WEST SUSSEX COUNTY COUNCIL CONSULTATION

TO:	Arun District Council FAO: Mr. S. Davis
FROM:	WSSC – Highway Authority
DATE:	16 March 2026
LOCATION:	Tesco Superstore Shripney Road Bognor Regis PO22 9ND
SUBJECT:	BR/24/26/PL Installation of single storey raised car park deck together with site alterations, car park reconfiguration, new access into car park, drainage alterations, creation of new drainage outfall, landscaping and other associated works.
DATE OF SITE VISIT:	9 March 2026
RECOMMENDATION:	More Information Required

Access plan. NTS

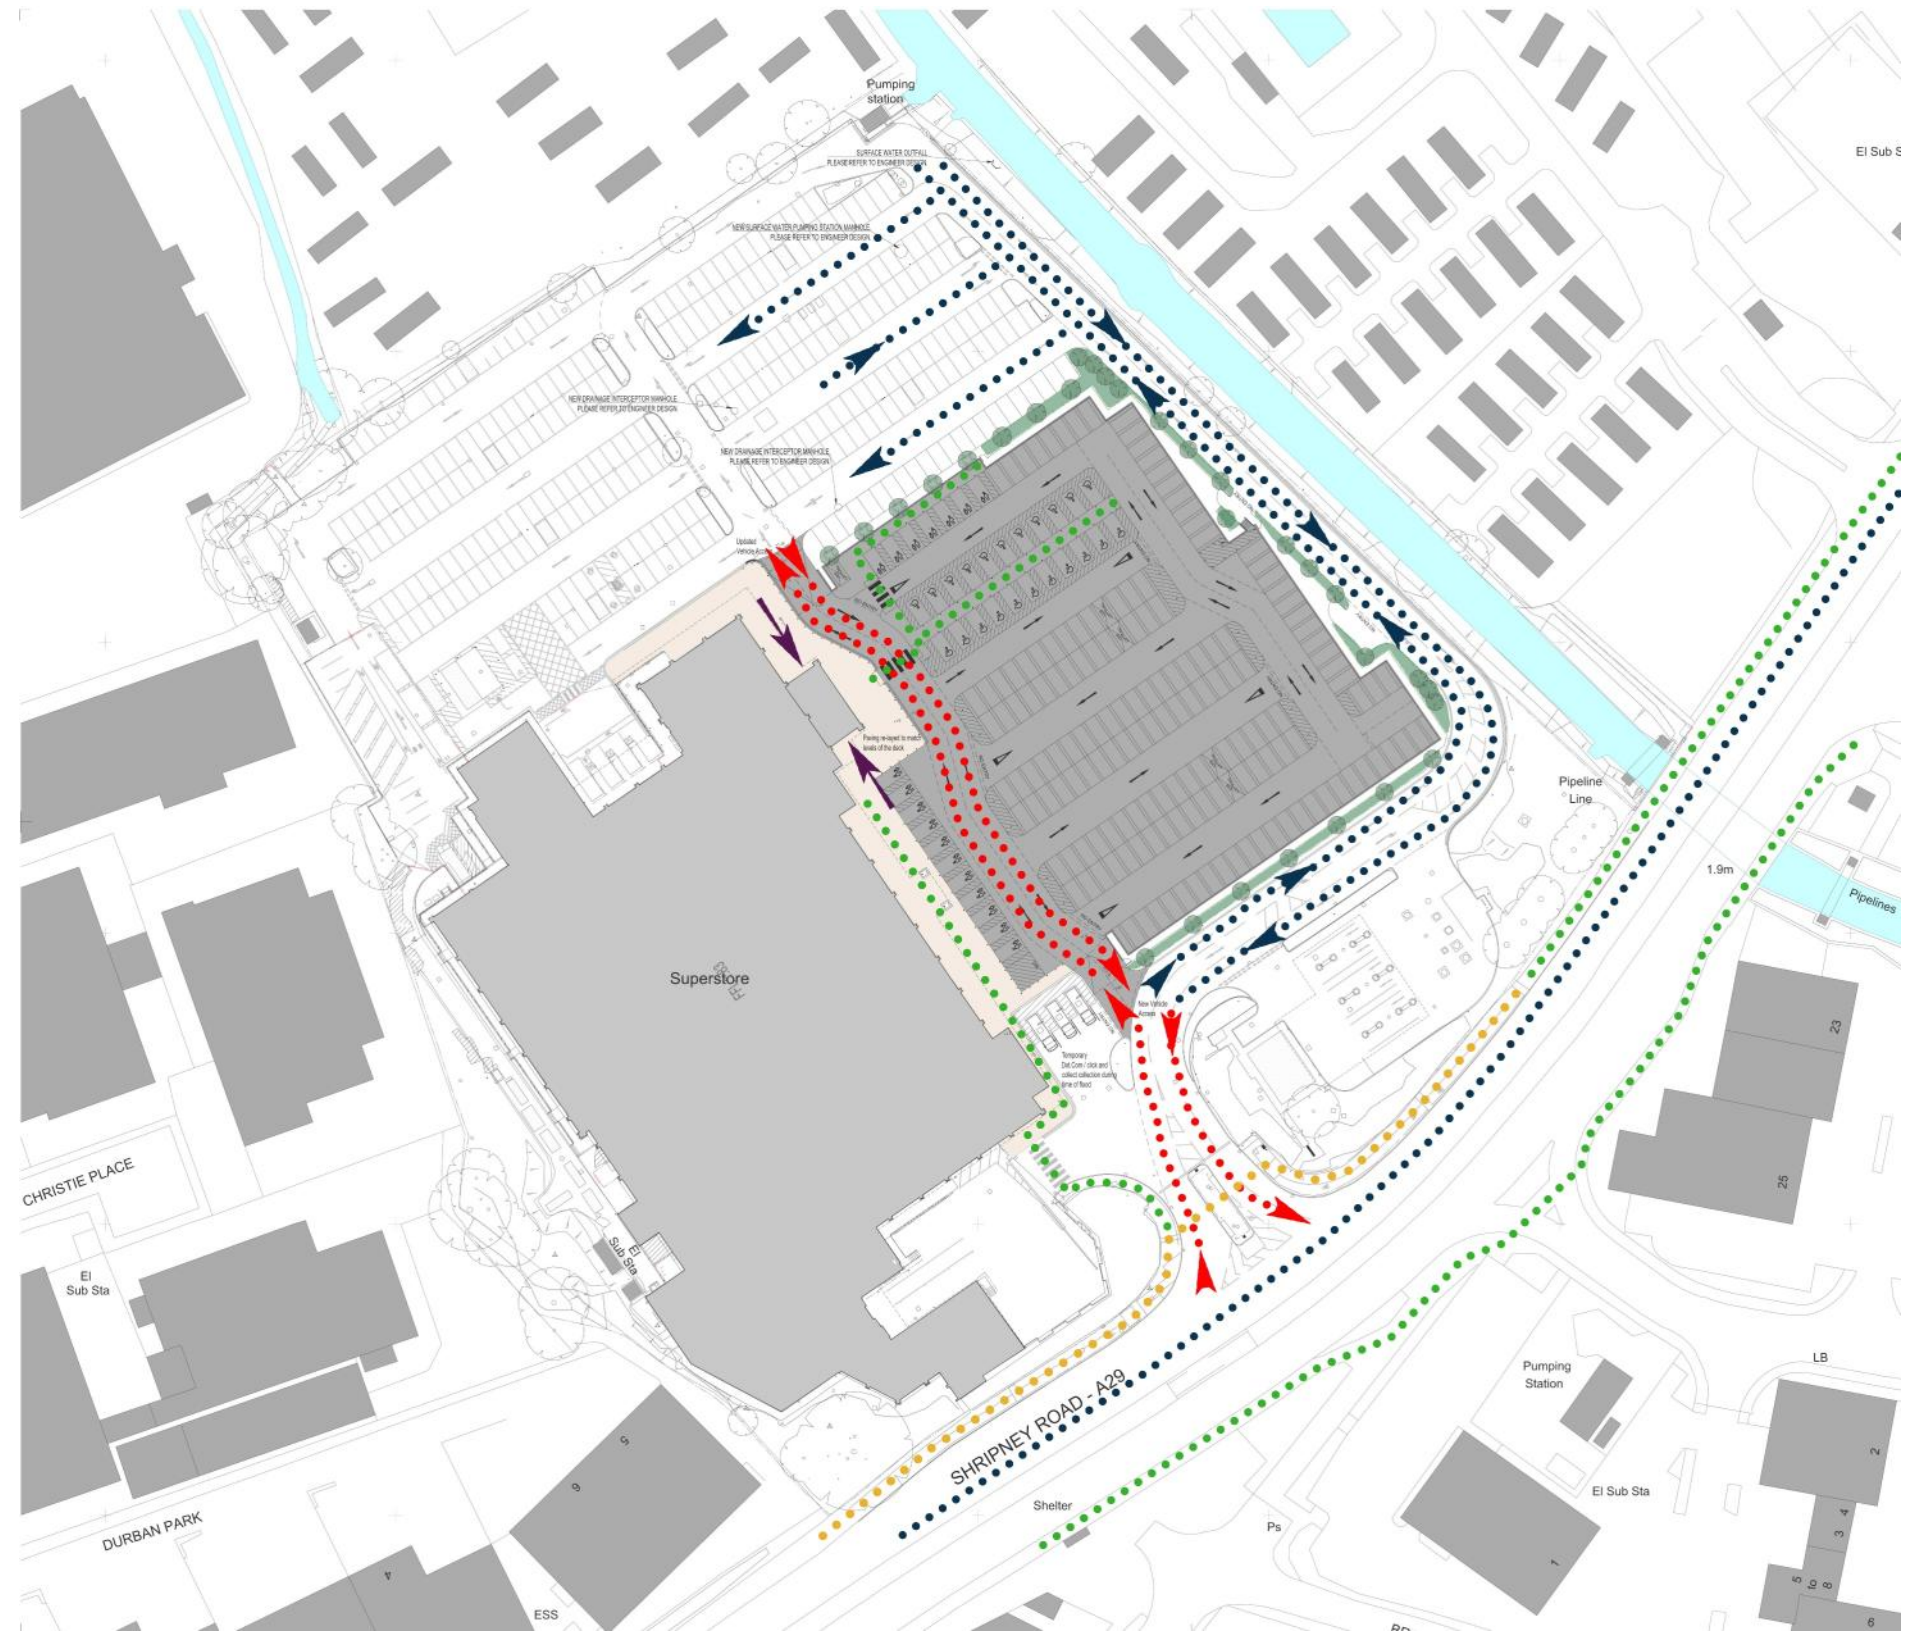
3. Access for mobility-impaired users – Access for mobility impaired users does not appear to be demonstrated (e.g. Only steps up and down to and from the raised deck appear to be shown but other than the vehicle access ramps, no bespoke ramps appear on the plans). Applicant to provide plans.
4. Bus access – The existing bus waiting area is shown removed from the site and replaced with temporary 'dot-com' collection and delivery bays. This would be a retrograde step for those users wishing to get to the site by public transport. Therefore, the Highway Authority recommends that it remains and another location found for the temporary 'dot-com' delivery vehicles.
